Revise title to
"Pre-subdivision
Grading and Erosion
Control Plans"

WATERVIEW EAST COMMERCIAL
GRADING AND EROSION CONTROL PLANS

PROJECT NO.
196195000

SHEET
C 3.0

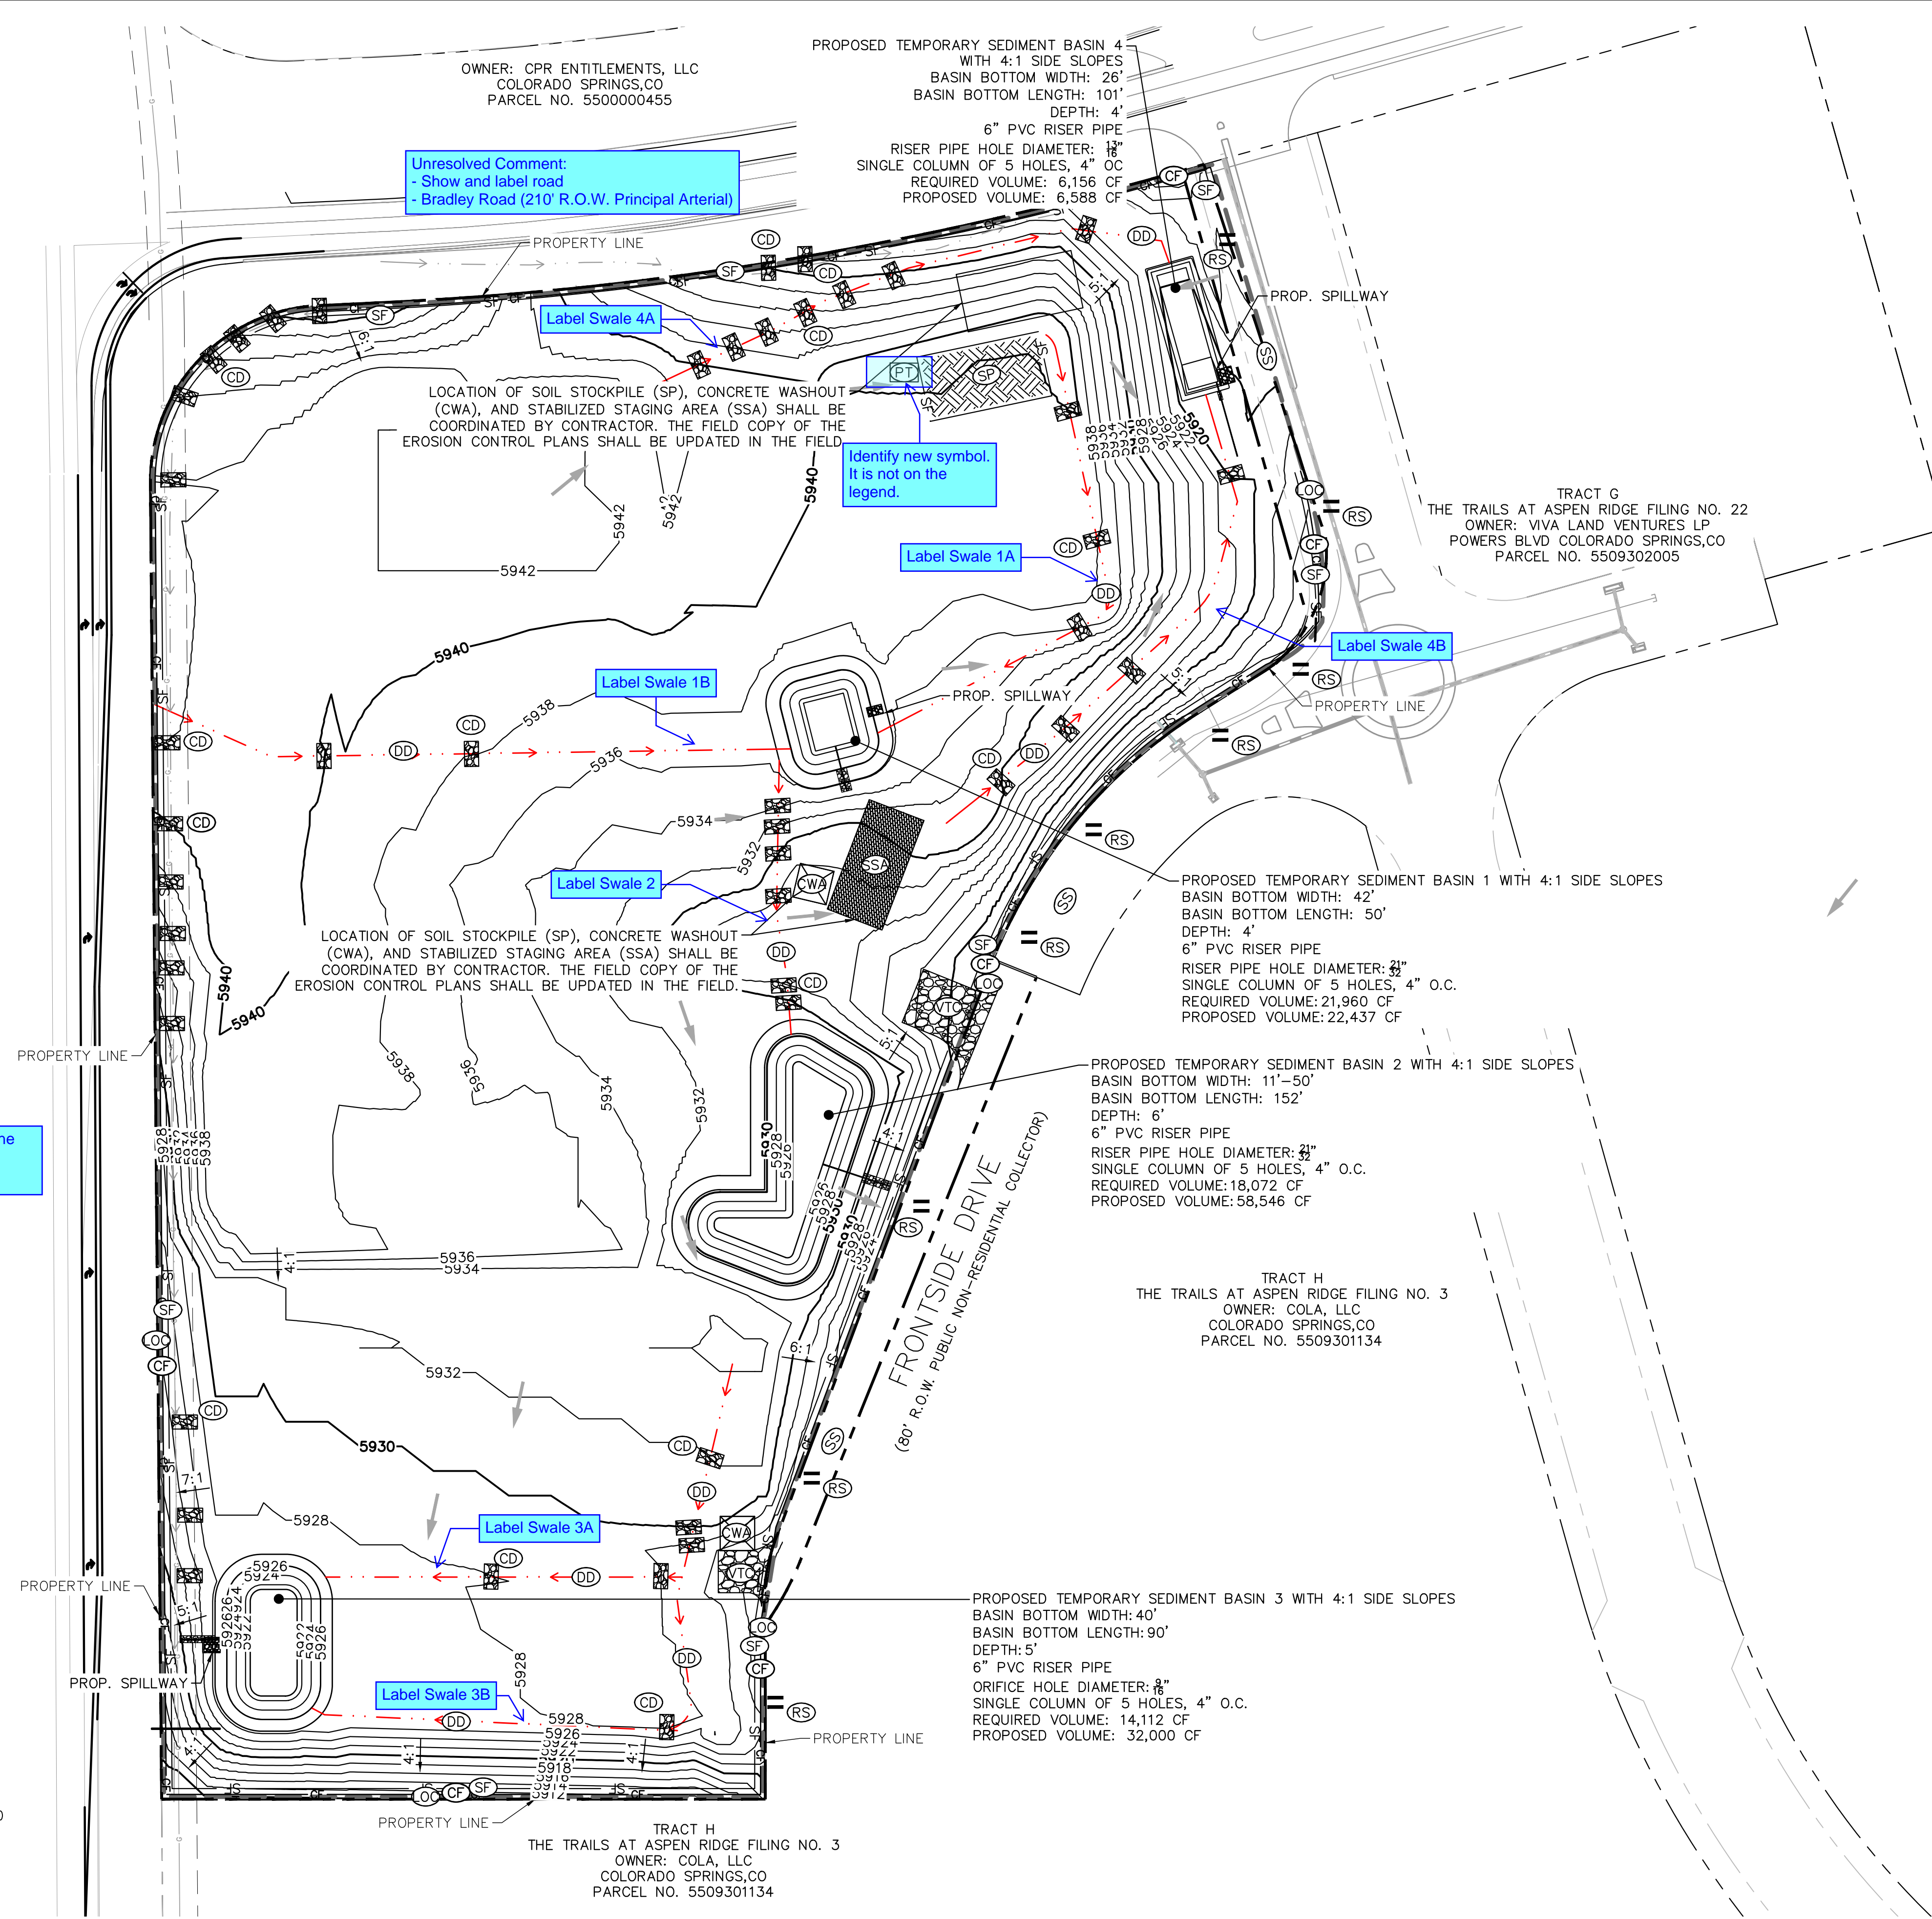
- Change to "Waterview Commercial Investors, LLC" to match all other documents

Revise to "Joshua Palmer, PE, County Engineer/ECM Administrator"

Provide full legal description as shown on cover of preliminary plan

WATERVIEW EAST COMMERCIAL
GRADING AND EROSION CONTROL PLANS
GEC INTERIM PLAN

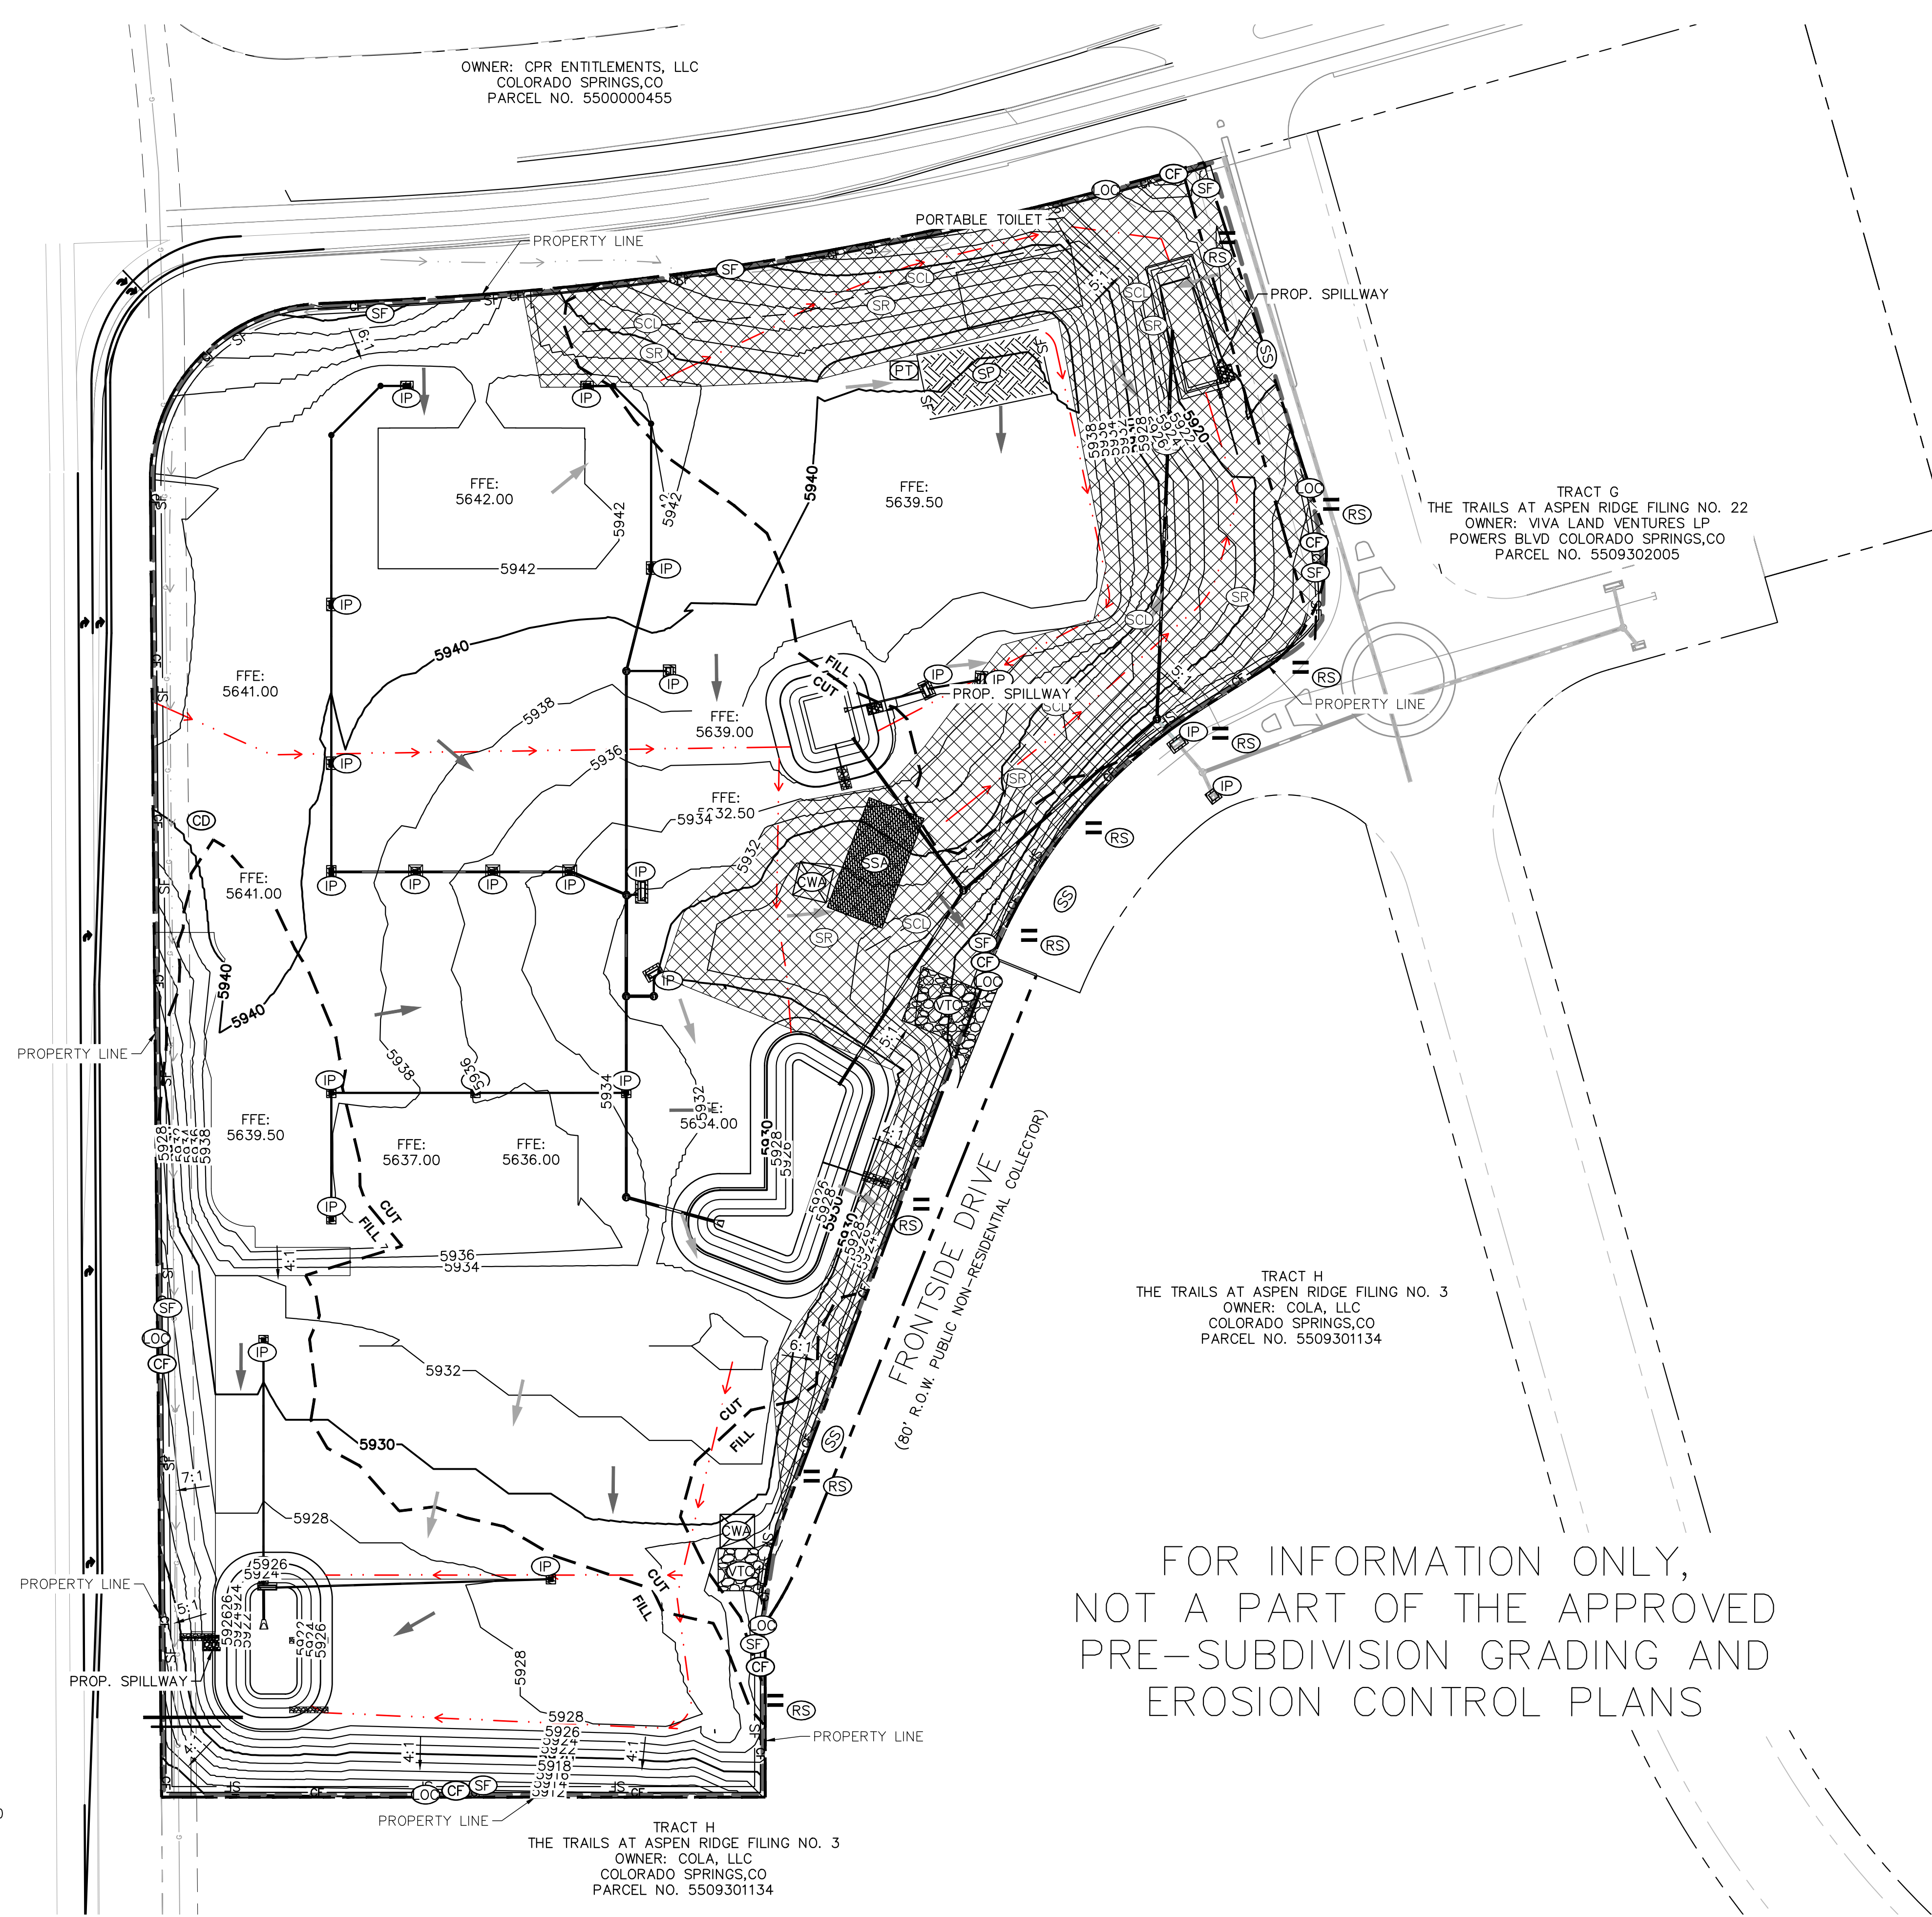
Turn off all proposed infrastructures (C&G, Striping, stormdrain pipes, and inlets). This application is for early grading only which is limited to earthwork operations.

Did not see any diversion ditches on the plan. Please show clearly and include detail or remove from legend

Slopes steeper than 3:1 will need blanket protection

label slopes.

Coordinate with the manufacturer on the retaining wall layout and horizontal separation between tiers. Typically these products are designed at a specific radius vs a 90d bend.
